Jeff;
This is in regards to the Williams Country Estates Short Plat. All conditions set forth in the KRD General Guidelines have been met, therefore, this short plat has been approved. If you need additional information, please let me know.

RE: Williams County Estates Short Plat SP-09-00016

Thank you for the opportunity to comment on the Williams Country Estates short subdivision of approximately 41.26 acres into 4 lots, proposed by Mildred I. Williams Trustee [SP-09-00016]. We have reviewed the application and have the following comments.

SUBJECT: Williams County Estates Short Plat SP-09-00016

WILLIAMS COUNTRY ESTATES SHORT PLAT
 PART OF SECTION 11, T. 18 N., R. 19 E., W.M.
 KITITAS COUNTY, WASHINGTON

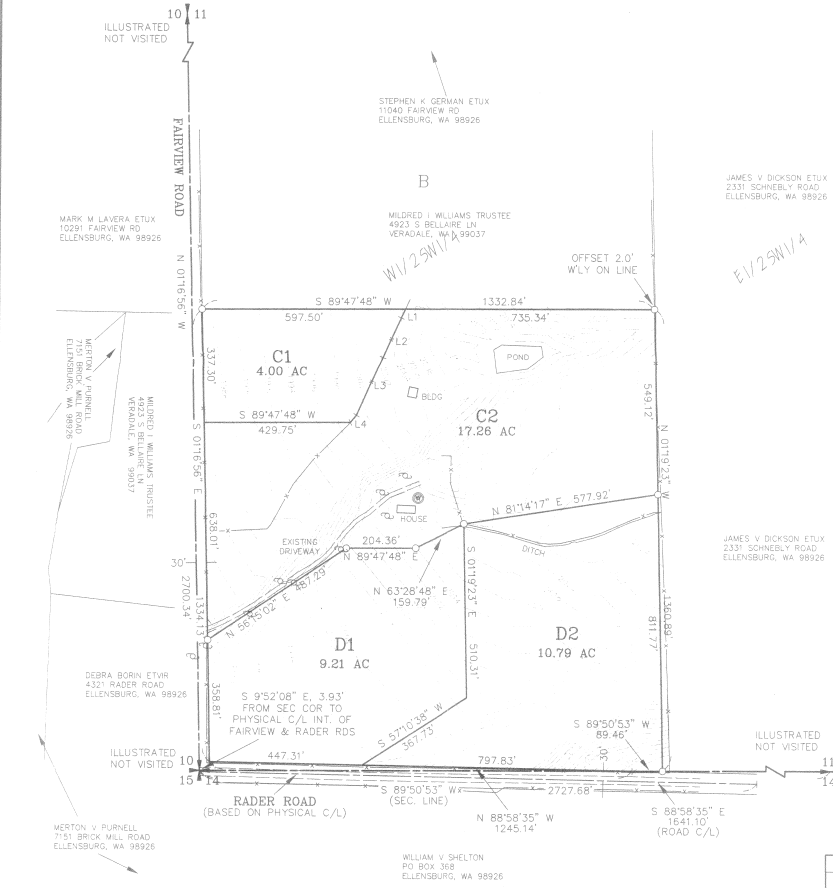
Thank you for the opportunity to comment on the Williams County Estates Short Plat, SP-09-00016. All residential well connections serving the proposed lots shall be required to have meters installed. Metering results shall be recorded in a manner consistent with Kittitas County and the State of Washington, Department of Ecology requirements. This requirement to meter only applies if you rely upon the RCW 90.44.050 exemption from permitting through ecology.

The final plat notes shall include the following two statements:

"The approval of this division of land includes no guarantee that there is a legal right to withdraw groundwater within the land division. The approval of this division of land provides no guarantee that use of water under the ground water exemption (RCW 90.44.050) for this plat or any portion thereof will not be subject to curtailment by the Department of Ecology or a court of law. "

"Metering will be required on all new residential well connections and metering results shall be recorded in a manner consistent with Kittitas County and Washington State Department of Ecology requirements."

Soil logs must be performed prior to the Public Health Department recommending preliminary approval of the plat. The Public Health Department's approval of the soil logs will meet the septic availability requirement for recommending preliminary plat approval.

At this time the application does not contain sufficient information to make a determination of adequate water availability or soil assessment to determine the land area is suitable for onsite sewage systems. The above mentioned items need to be submitted to the Public Health Department in order for the plat application to be recommended for approval.
